Re: Old North State Catering Commissary

Application #1904-003

Harnett County Health Department
Harnett County Environmental Health

FLOOR PLAN
SCALE: 1/4" = 1'

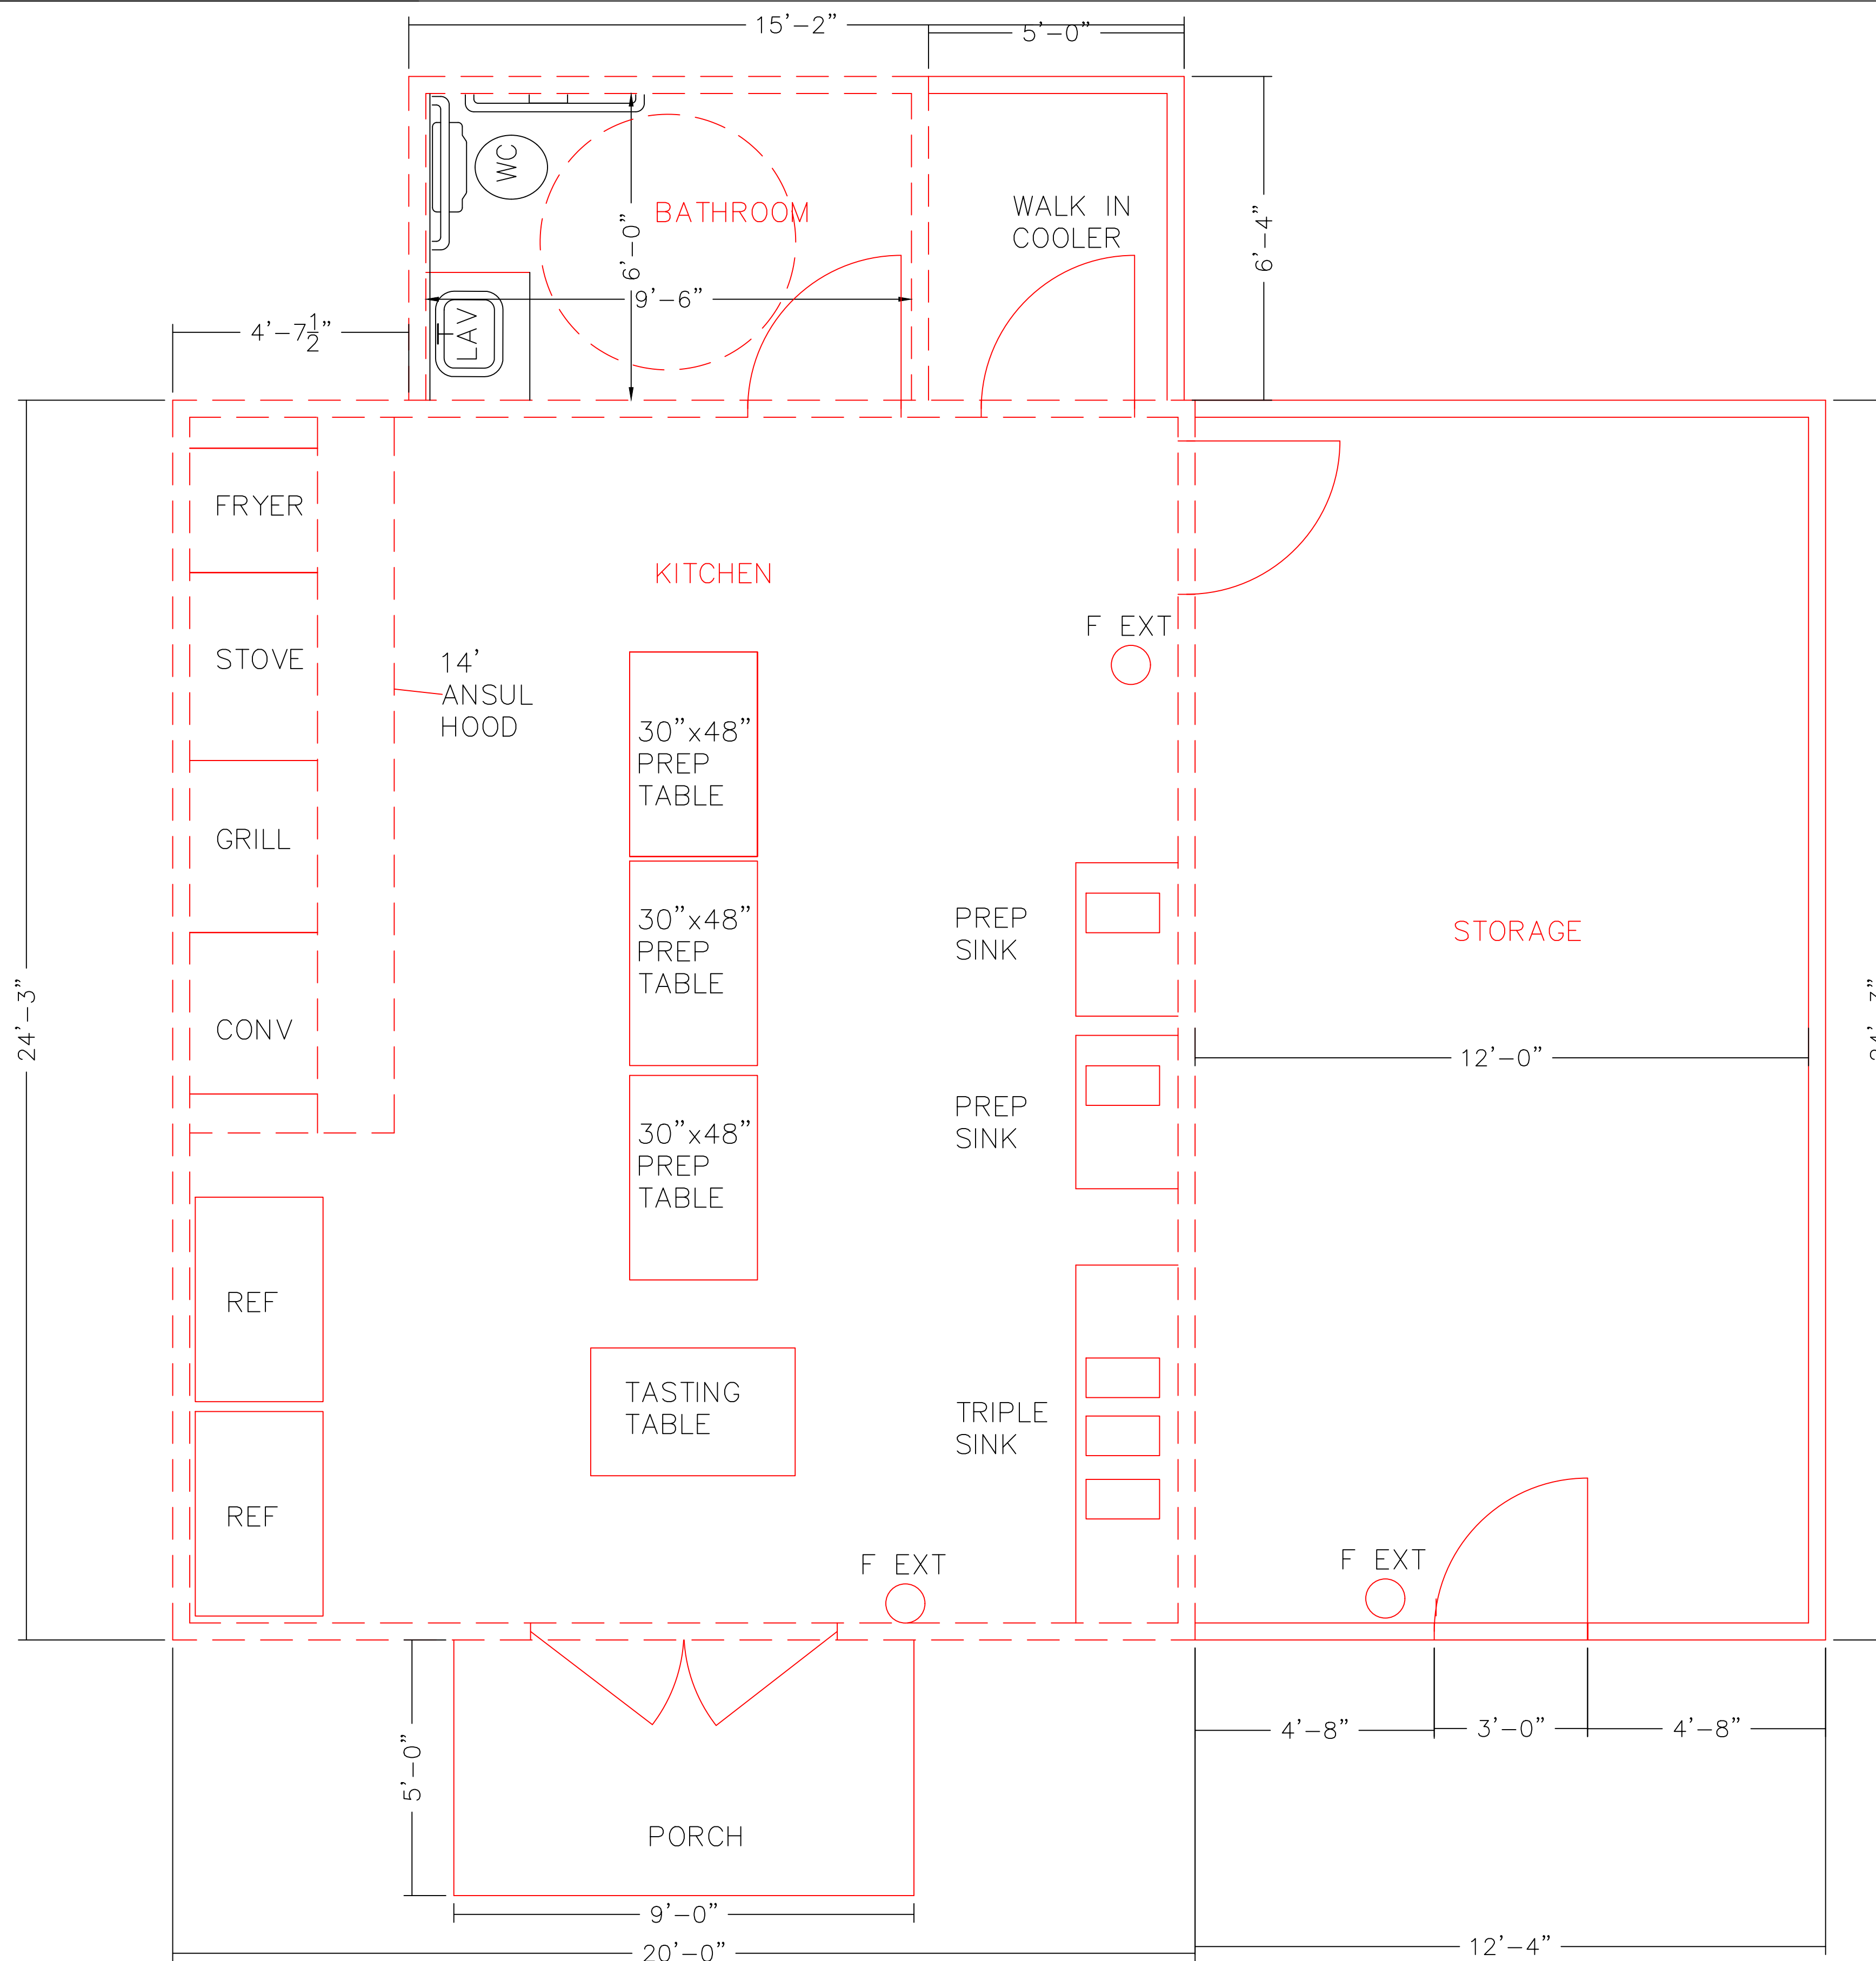
4. Dishmachine is drawn on plans as located beside the three compartment dishsink drainboard. Is this the correct location or do you intend to place it under the dishsink drainboard? Describe the intended use of the dishmachine (type of utensils). (see item 13 pertaining to location of dishmachine)

5. Indicate location of air drying shelves on floor plan and provide an equipment specification sheet. Do you intend to have pot racks? If so, provide location on floor plan.

6. Indicate location and number of dry good storage shelves on floor plan. Provide an equipment specification sheet.

12. Equipment must be drawn to scale and accurately presented. Dish sink and prep sink vats not shown as measurements specified on application.
13. Relocate dishmachine under right side drainboard of 3-compartment sink, move handsink between dishsink and closest prep sink (equipment may need to be shifted left, closer to door leading to storage room). Relocation of handsink is to help separate dishwashing and prep and get handsink closer to dishwashing area. Splashguards needed between prep sinks, handsink and dishwashing drainboard. Indicate location of splashguards on plan. Flow will be reevaluated on revised plans. Equipment location is subject to change on future reviews.

PLUMBING PLAN
SCALE: 3/16" = 1'

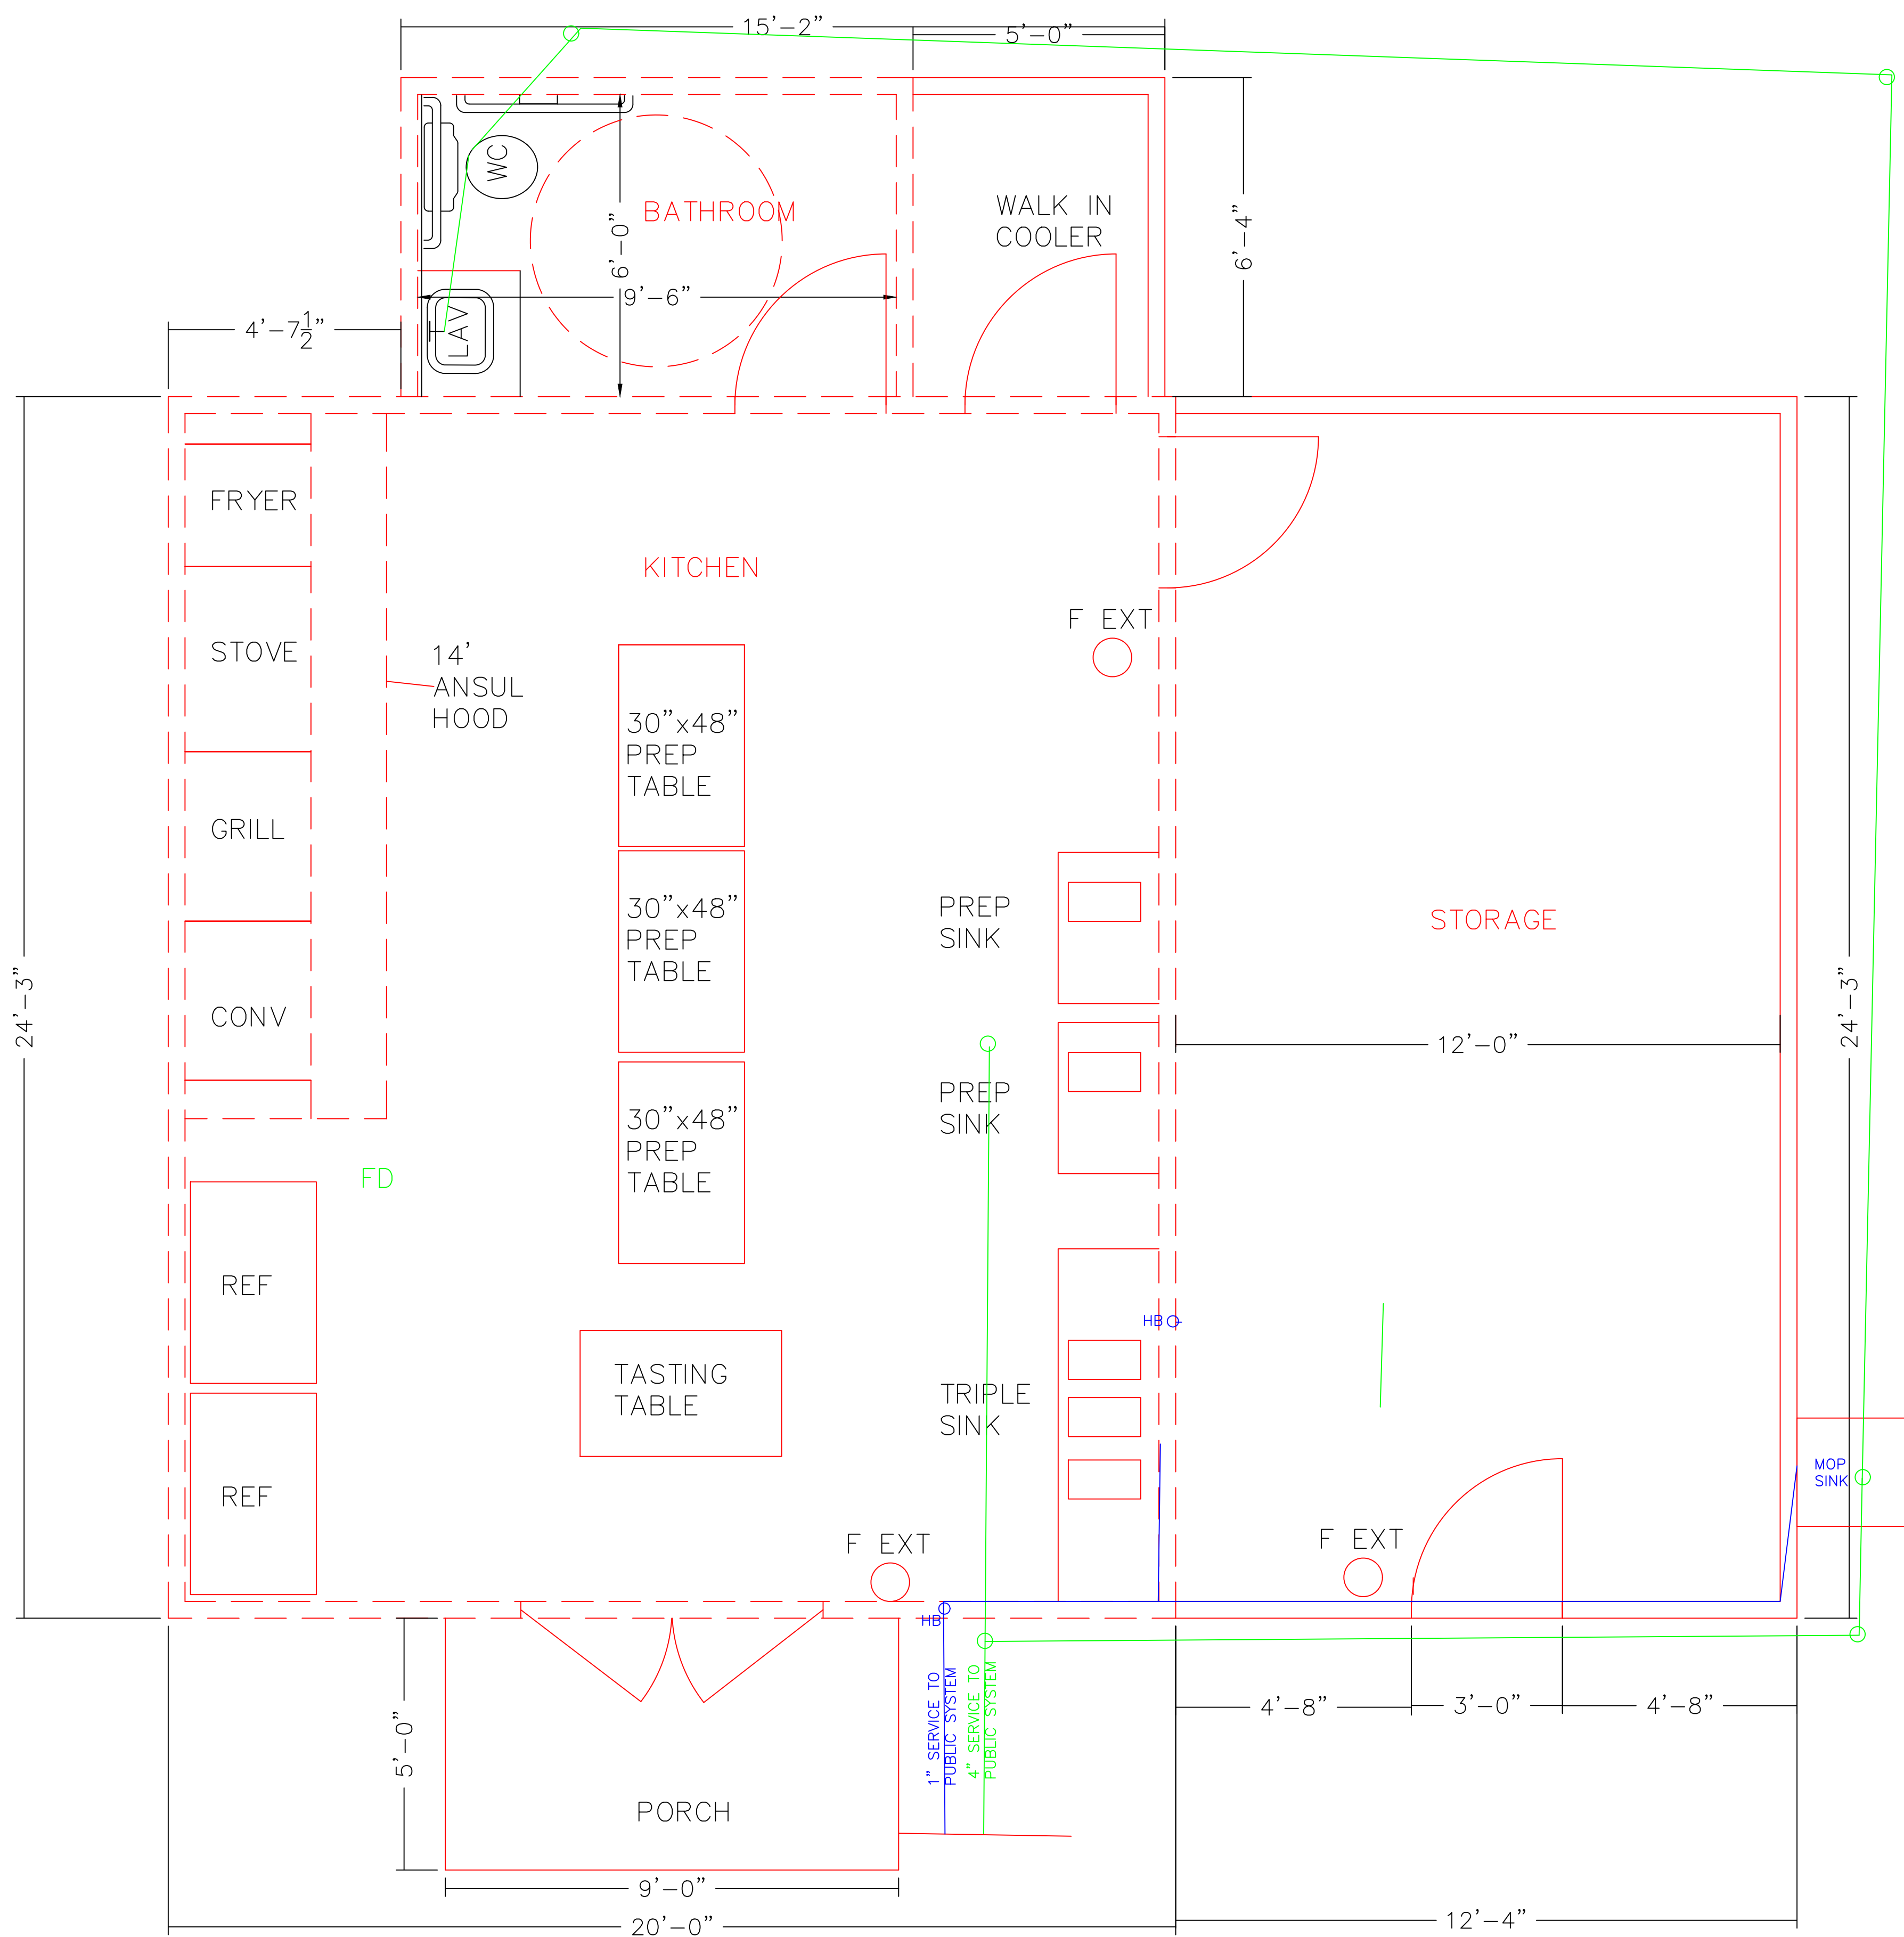
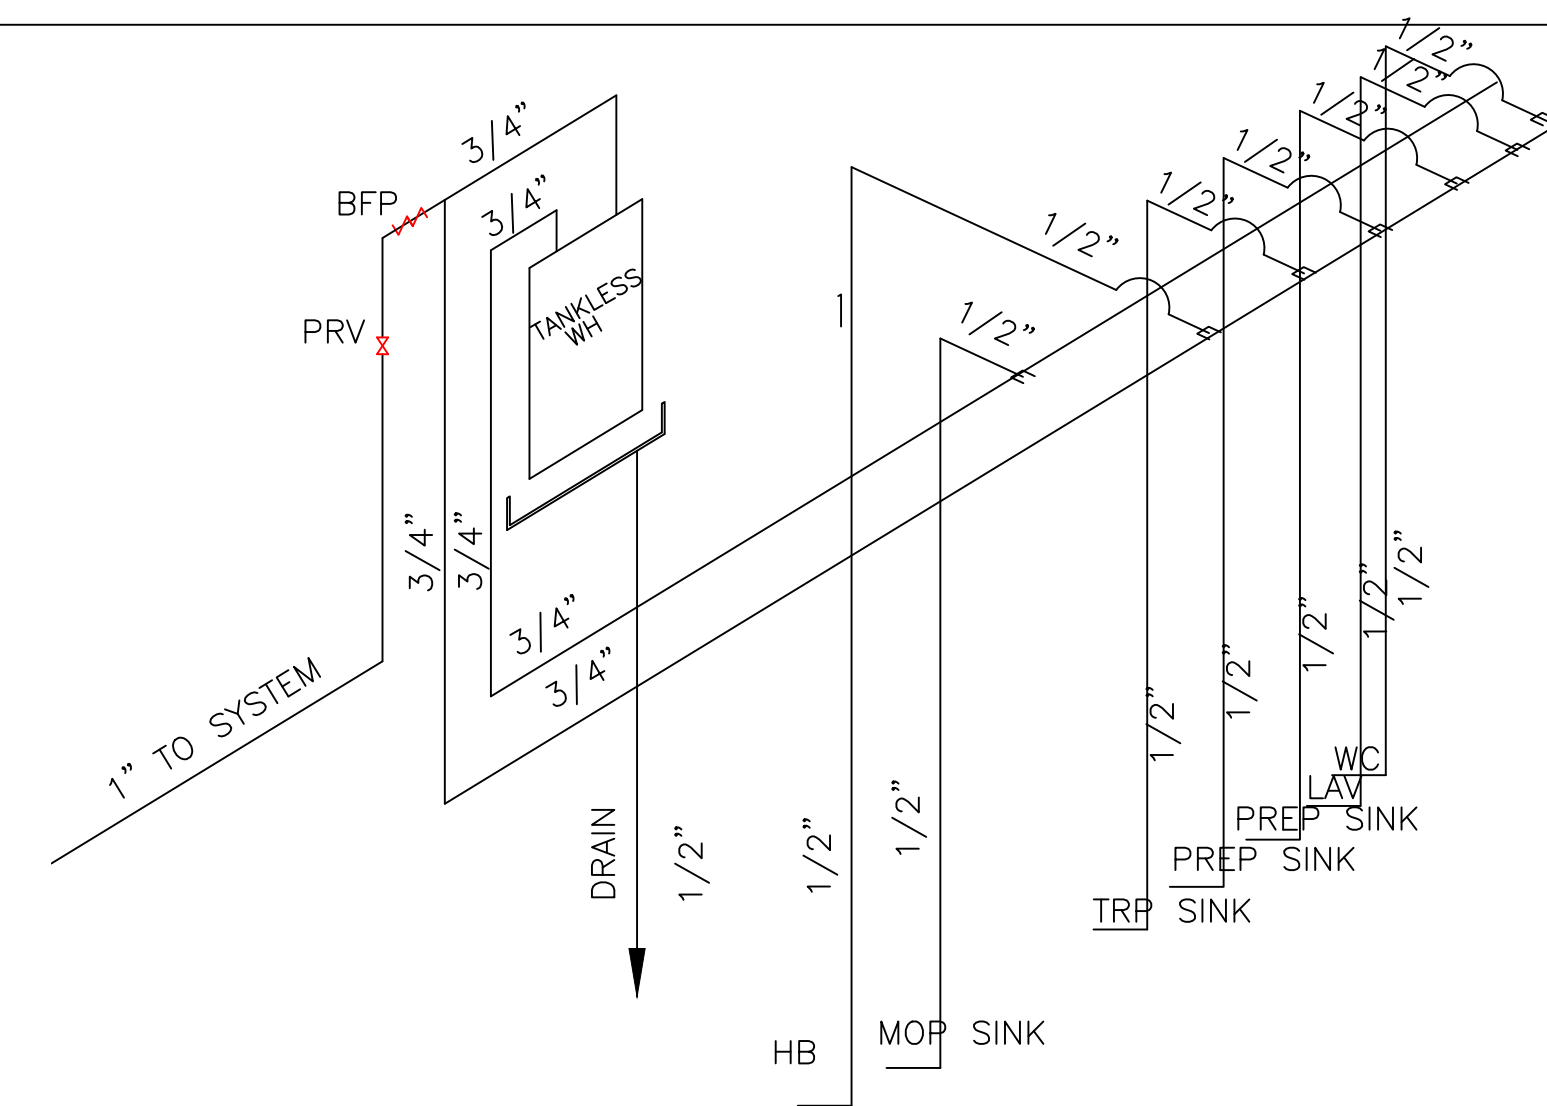
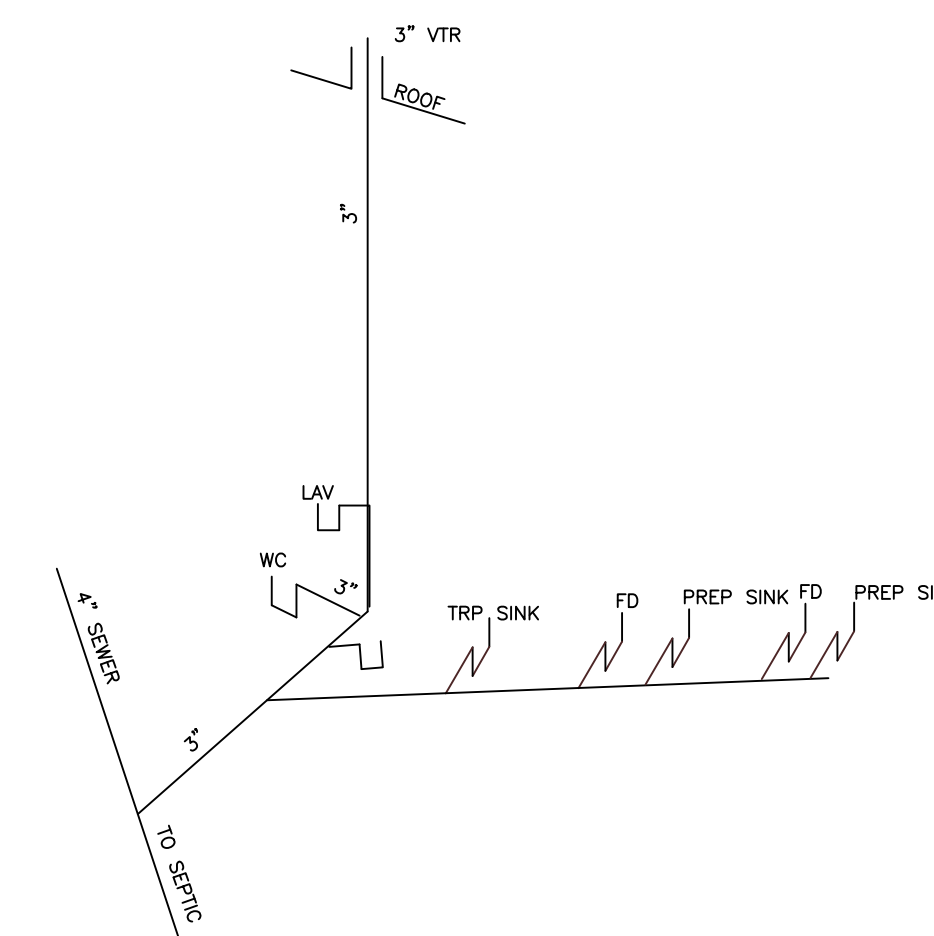
1. Plumbing plan-Indicate how sinks drain, whether direct or to a floor or hub drain. Clarify how many floor drains are present and locations. Show the flow of hot and cold water lines to water using fixtures. Include dishwasher on plumbing plan and specifications on how dishmachine is plumbed. Indicate location of grease interceptor.
